January 16, 2018

**RE: Titan Presbyterian Hotel Block – Sector Plan Map Amendment and Site Plan for Building Permit
Project #1011099, 16EPC-40085/40087**

Conditions of Approval – 16EPC-40087– Sector Plan Map Amendment

Conditions of Approval – 16EPC-40085– Site Plan for Building Permit

SHEET NUMBER

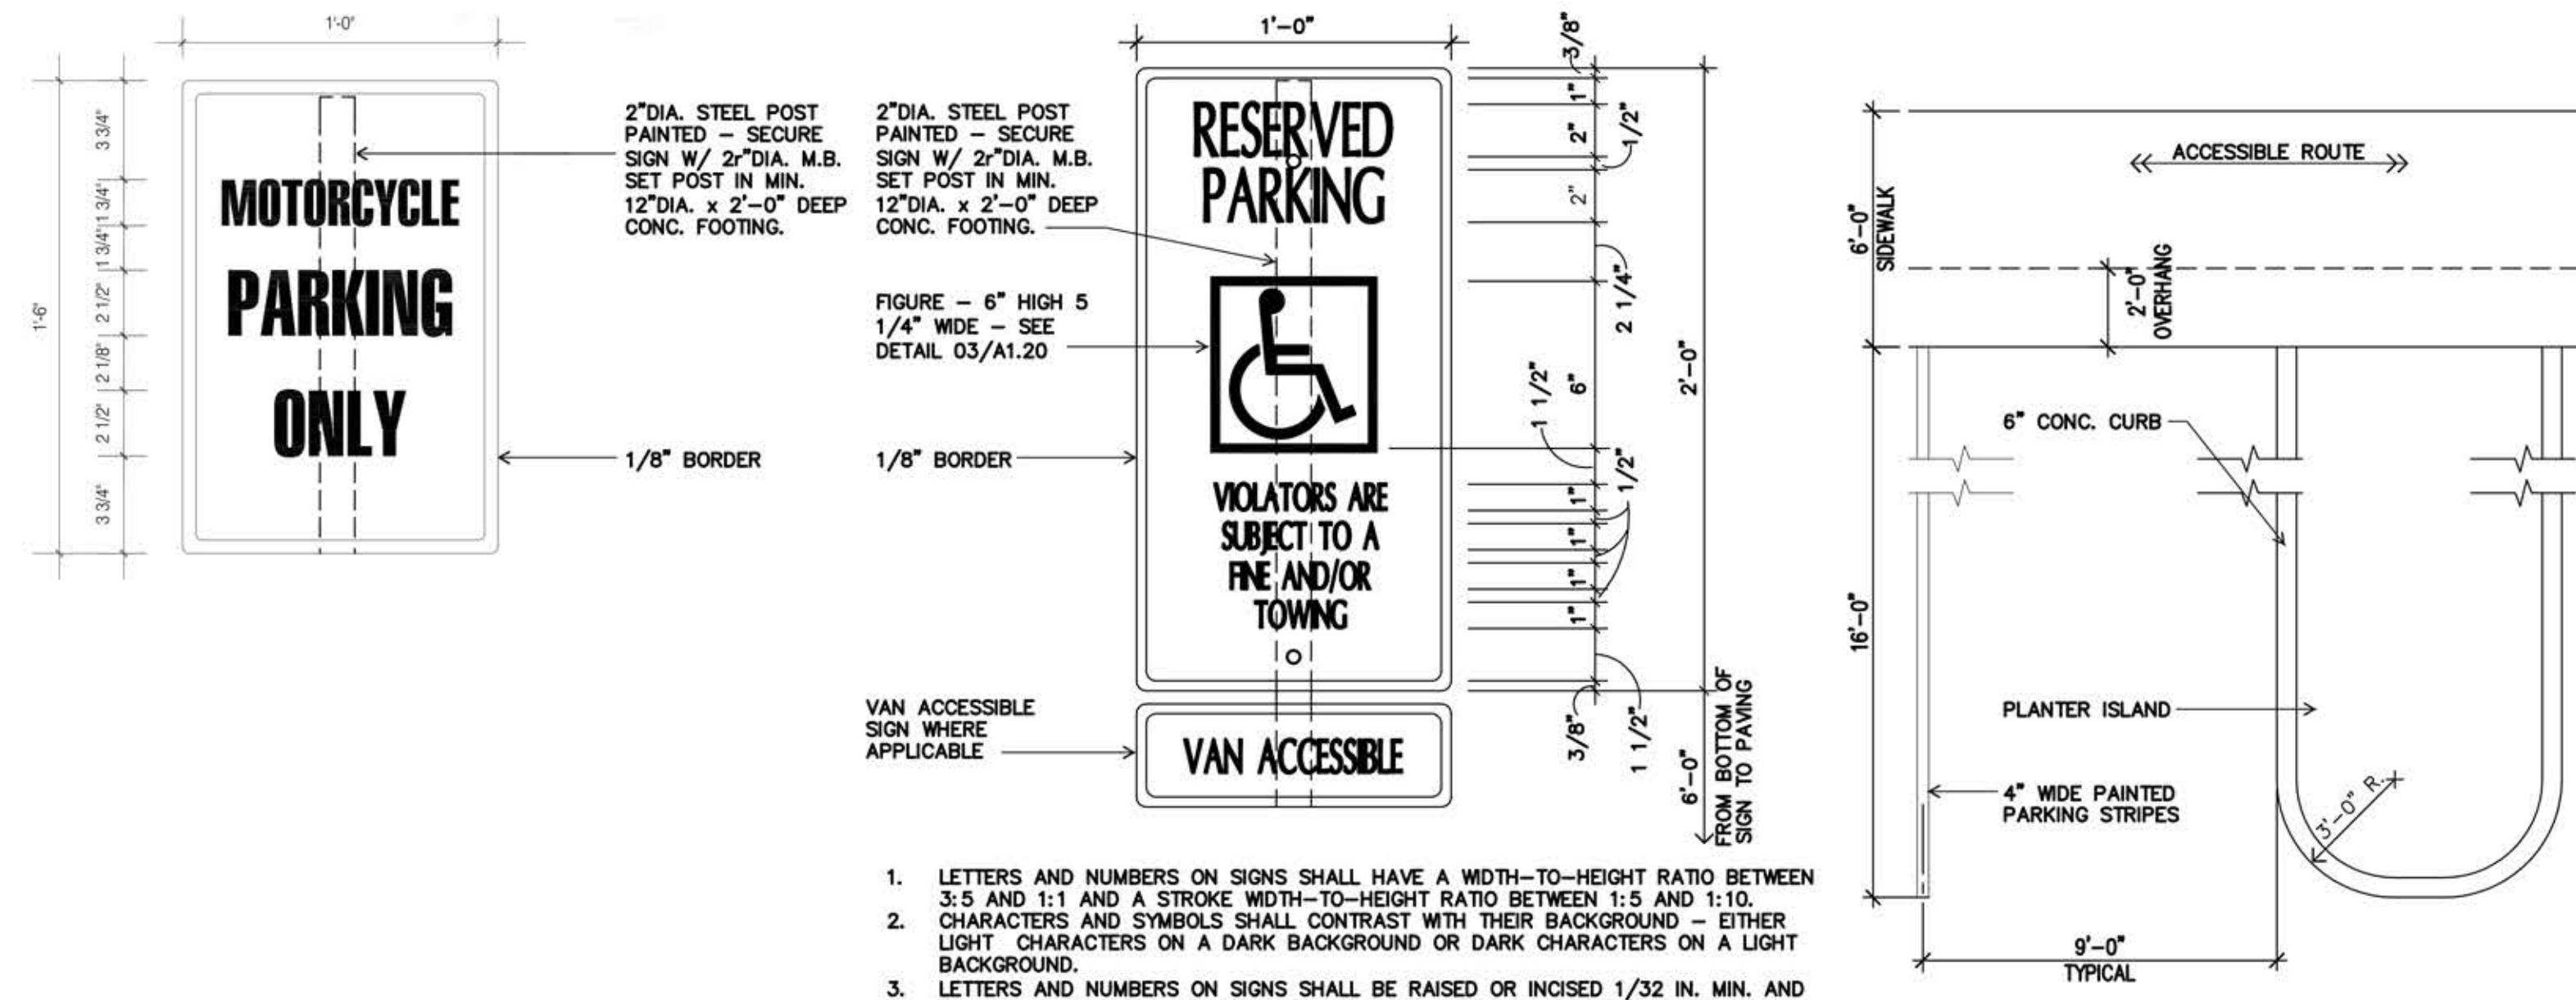
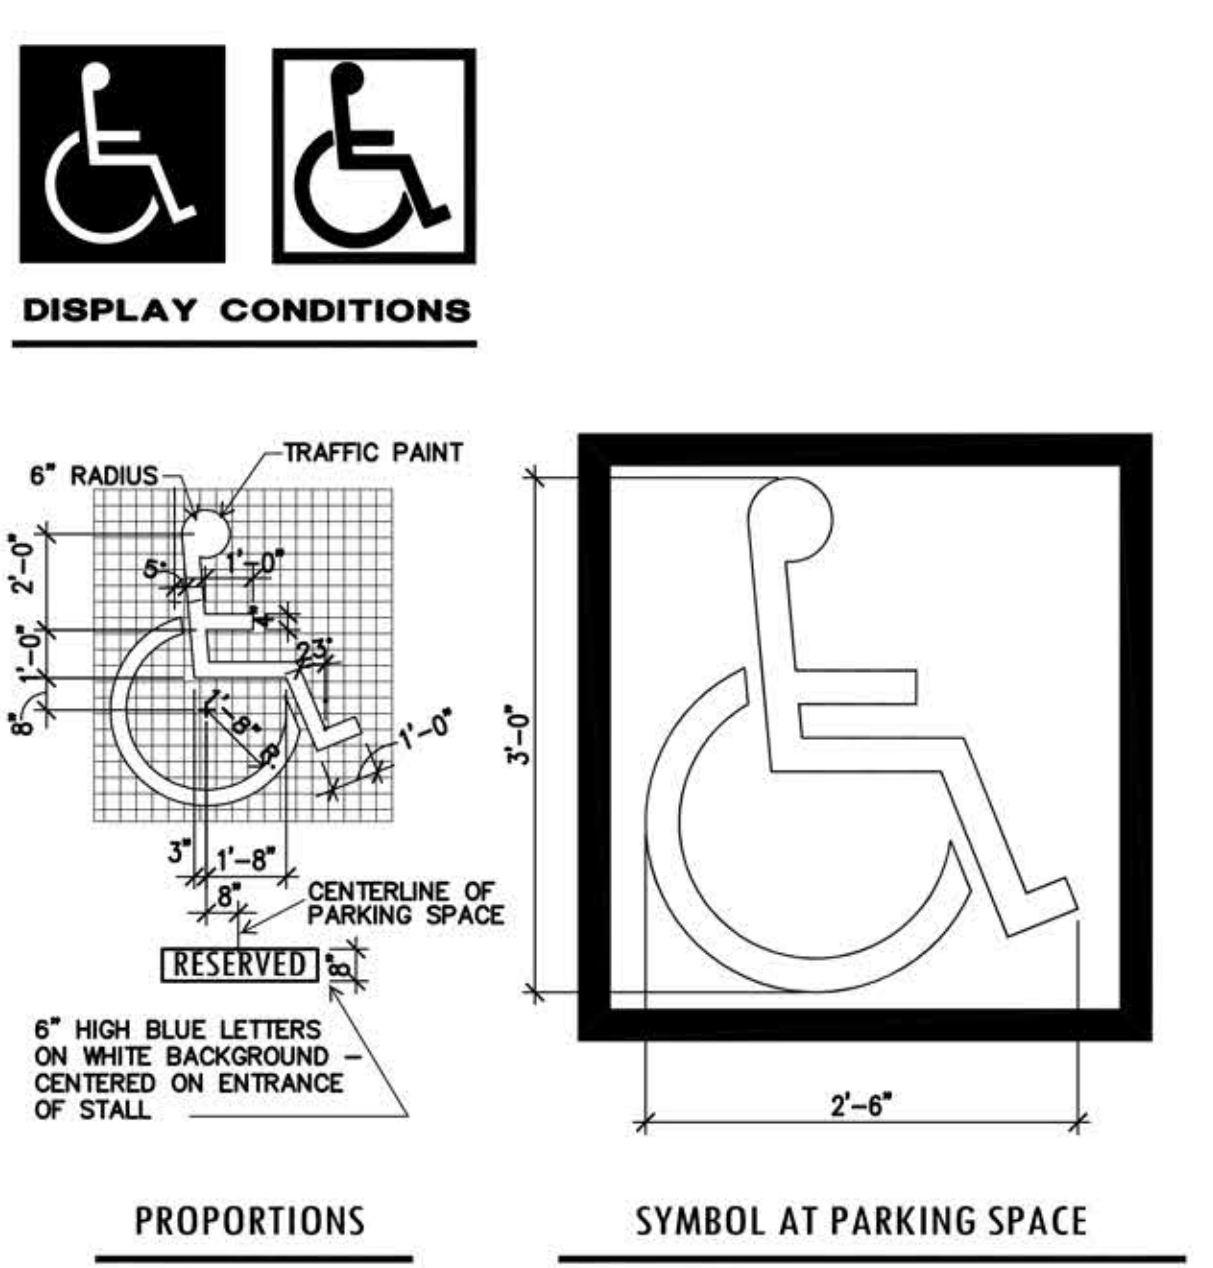
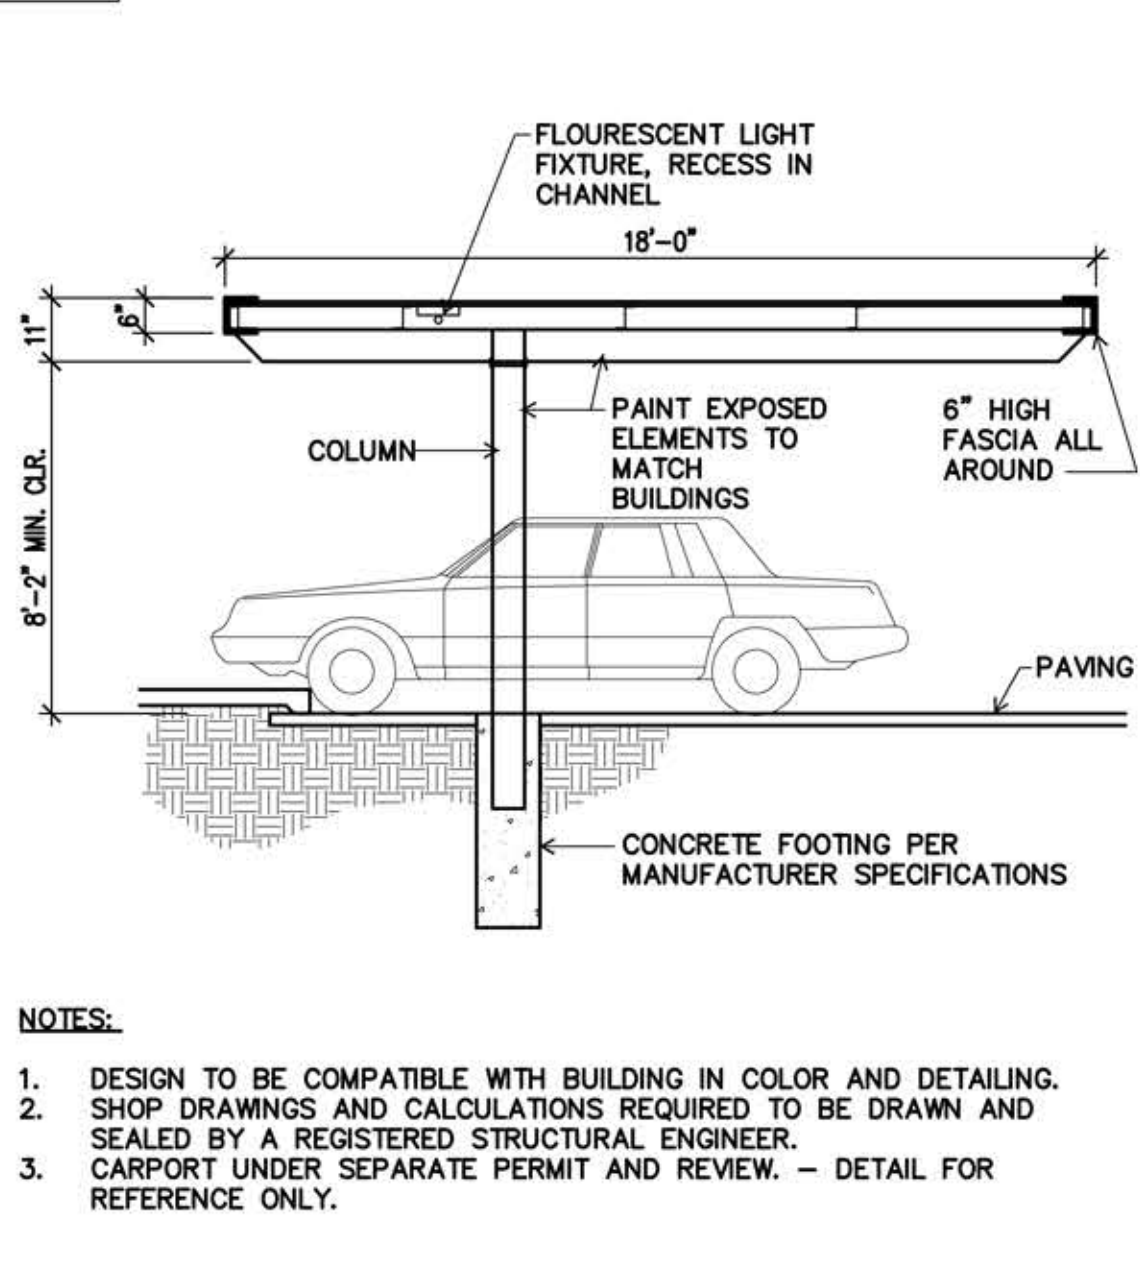
7. The site details sheet shall be updated to include more details on accessible parking spaces, signs, trash enclosure gate and wall details, accessible ramps, bicycle parking, and other information as necessary.

Site details sheets 8 and 9 have been updated to include additional details, as requested by this condition.

**SITE PLAN FOR**  
**BUILDING PERMIT**

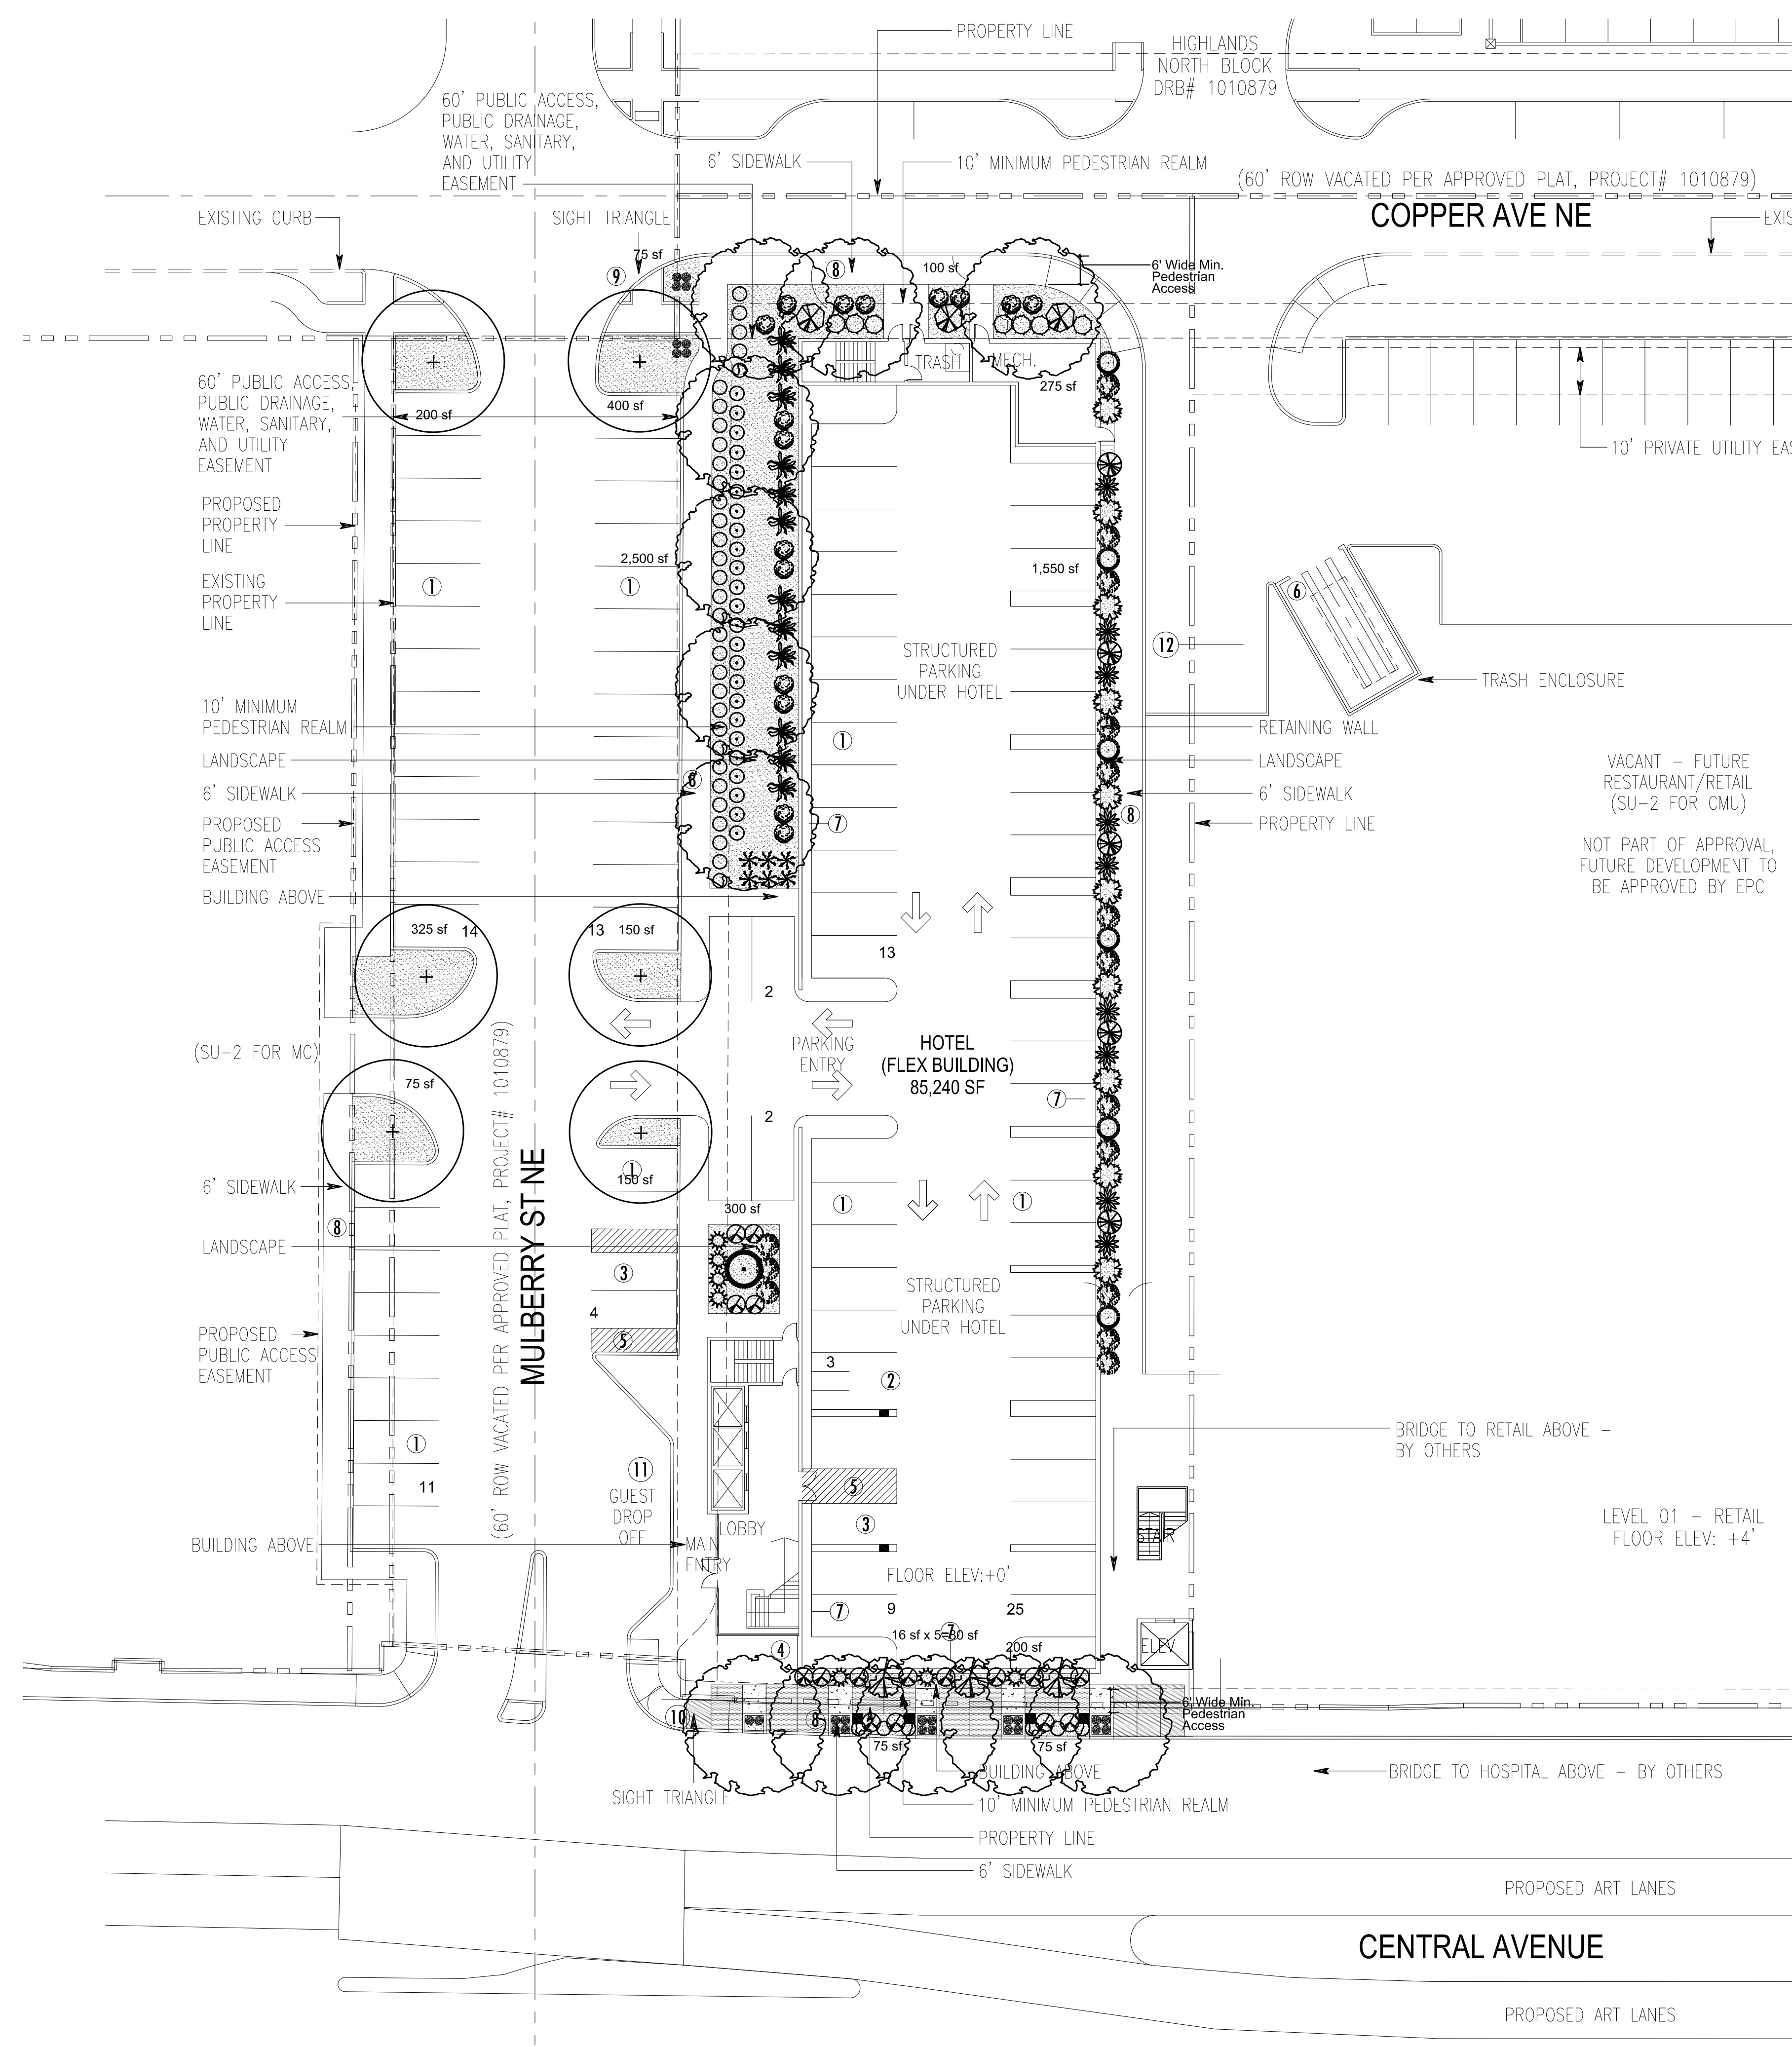
a. The section of the Zoning Code outlining the allowed 20 percent building height modification adjacent to transit shall be added to the plans.

b. The parking calculation numbers shall be updated to reflect the actual number of spaces provided.

c. Note #19 shall be updated to be a complete note on the intention to vacate adjacent rights-of-way.

4. The lighting note shall be updated to include specific references to the applicable code section 14-16-3-22(C)(6) where the requirements are found.

5. The signage note regarding future approvals shall be updated to clarify the code sections of the applicable requirements 14-16-3-22(8)(3)(n) and 14-16-3-22(C)(7).

Please see sheet 1, General Note 19 for reference to Zoning Code Section 14-16-3-22(A)(6)(B)(1)(C), outlining the allowed 20 percent building height modification.

The parking calculation numbers have been updated to include required and provided spaces for motorcycles and bicycles. Please see the first sheet of the set.

Note #19 is now note #20 and has been updated to read "Mulberry Street and Copper Avenue rights-of-way have been vacated. An Official Notice of Decision was issued by the City Planning Department on January 23, 2017 for Project #1010879, 16DRB-70447. The Plat associated with this action was recorded on June 13, 2017 for Project #1010879, 17DRB-70119."

Lighting note #17 has been updated to include specific references to the applicable code section referenced above. Please see sheet 1.

Applicable code section requirements have been added to signage note #21. Please see sheet 1.
